Application No: BN/11/22/OUT

Site Address: Barnham, Eastergate, Westergate BEW Parcel SC1 Barnham

Thank you for your internet representation made on 3rd March 2022 which has been recorded as an objection with the comments as follows:

On review of parameter plan 00605 i have the following objections ;

Movement and Access Parameter Plan

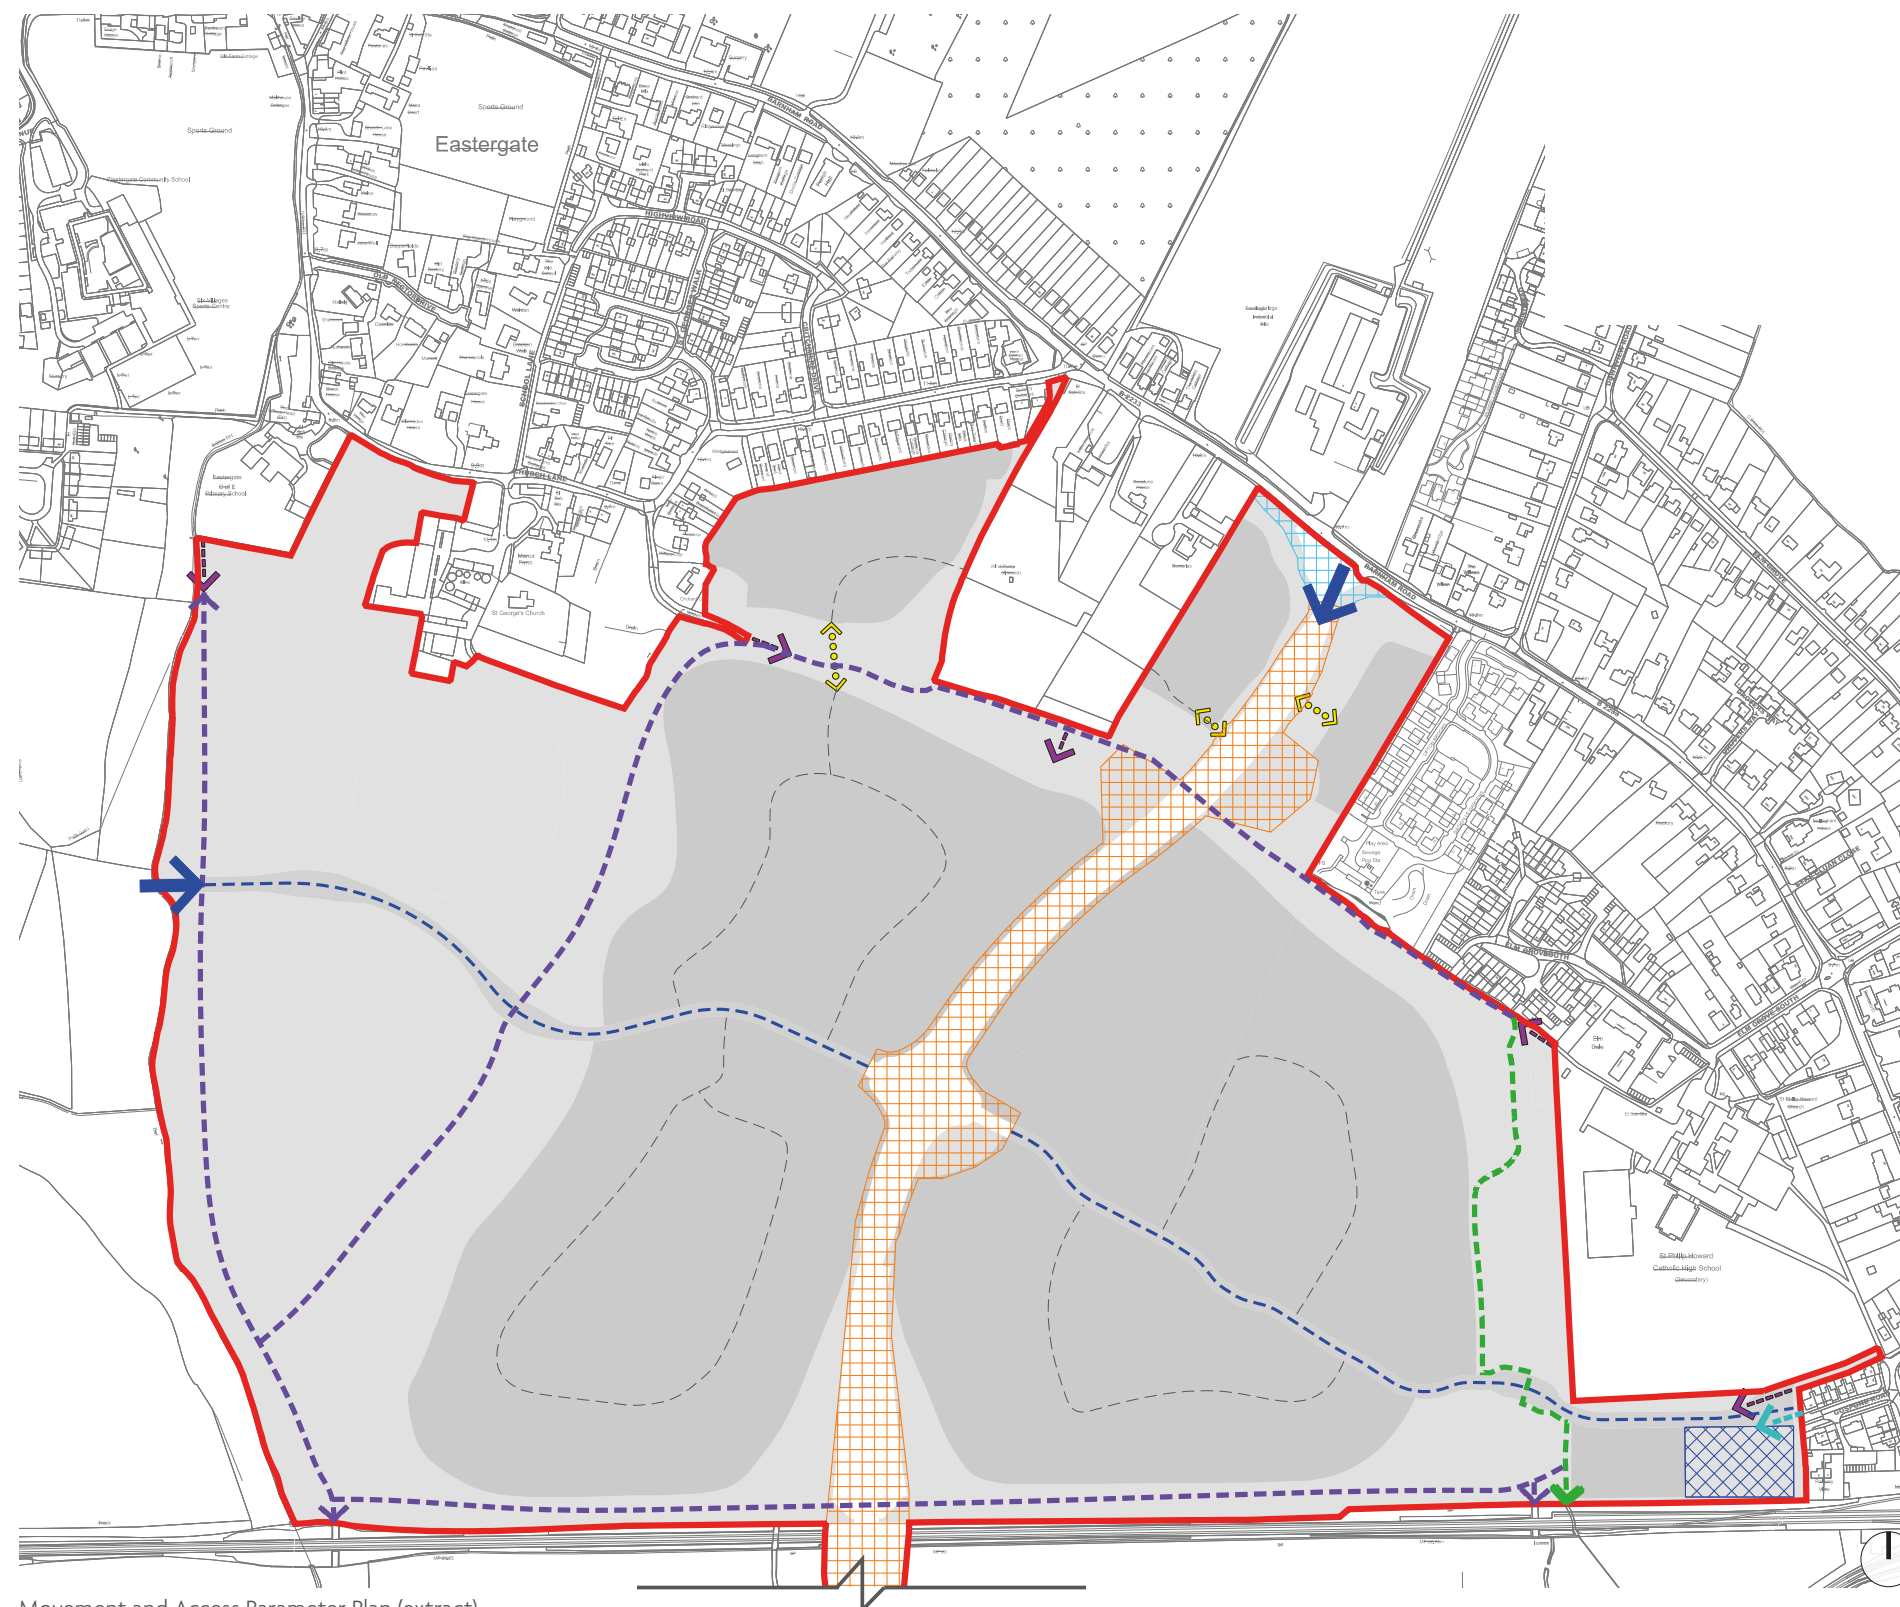
1) Proposed pedestrian / cycle path boarding the side of my property will impact on the peace , privacy and security of my property where no previous path or right of way existed .

The access point which potentially will be the front of my drive could hinder access to my property and be dangerous .

2) The East West access road looks as though you may be planning on linking to Gospond Road . This is a small residential road that would not be suitable a link road or be able to sustain any additional traffic .
